**Section 75W Modification Application No. 3 (Major Project MP 10_0105)
44-46 Walker Street, Rhodes**

This letter has been prepared by Urbis Pty Ltd on behalf of Waterpoint Site 1 Lessor Pty Ltd and Waterpoint Site 2 Lessor Pty Ltd in response to the NSW Department of Planning & Infrastructure (DoPI) request for additional information dated 22 October 2013, with regard to MP10_0150 MOD 3 (the Modification).

LEVEL 1

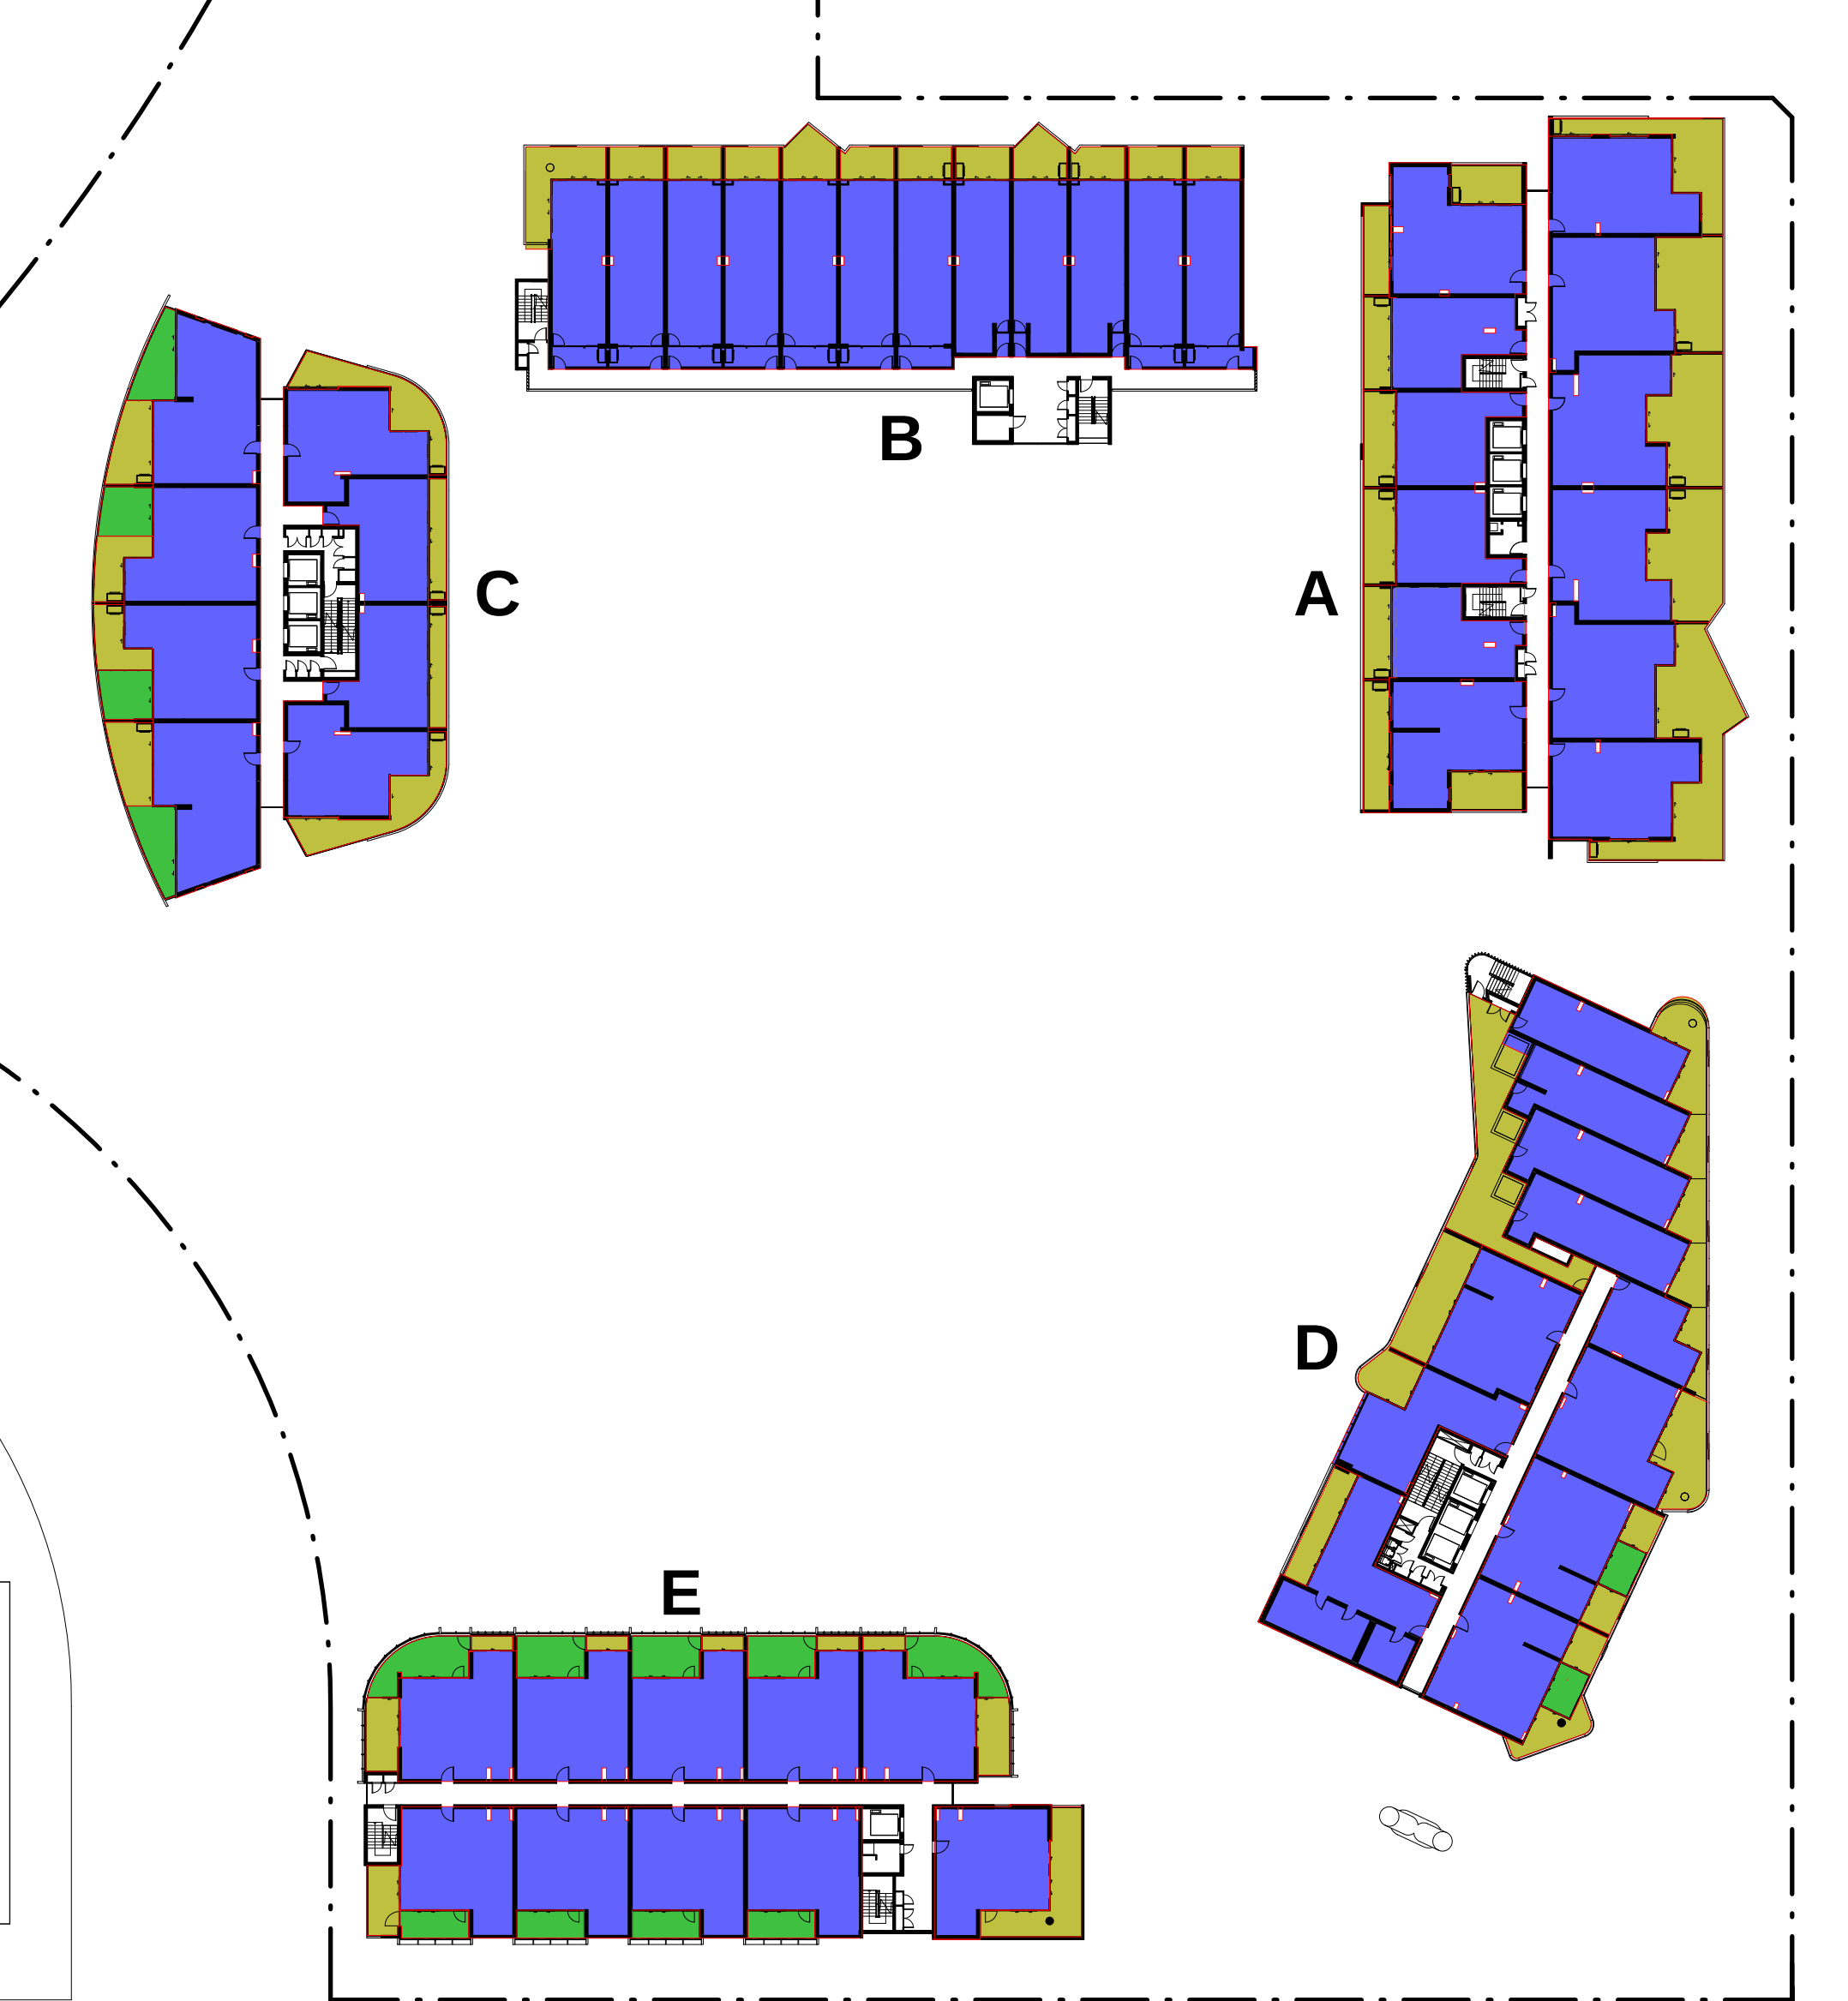
The Department have requested clarification that the definition used to calculate GFA for the proposed modification is the definition contained in Canada Bay Local Environmental Plan 2008 (CBLEP 2008). It is confirmed that the GFA definition for Rhodes West contained at Clause 4.4 (2A) of the CBLEP 2008 has been used to calculate the GFA of the Modification.

Separate calculations of the gross floor area of the development under the following Environmental Planning Instruments have been requested:

As noted above the gross floor area (GFA) has been calculated in accordance with the definition contained in the *Canada Bay Local Environmental Plan 2008* (CBLEP 2008) (Cl. 4.4(2A)). This is the relevant definition as it was the applicable at the time of lodgement of the original Major Project Application MP 10_0105. Subsequent modification applications (MOD 1 & 2) have been assessed and determined by the Planning Assessment Commission with reference to CBLEP 2008.

ITEM	APPROVED	PROPOSED	VARIATION
Total Floor Space	56,513m ²	57,351m ²	+838m ²
Retail Floor Space	1348m ²	1528m ²	+180m ²
Residential Floor Space	55,165m ²	55,823m ²	+658m ²
Wintergardens	2818m ²	4037m ²	+1213m ²
Total Units	743	759	+16
Unit Mix			
▪ 1 bed / studio	306	356	+50
▪ 2 bed	415	387	-28
▪ 3 bed	22	16	-6
Residential Parking	743	759	+16
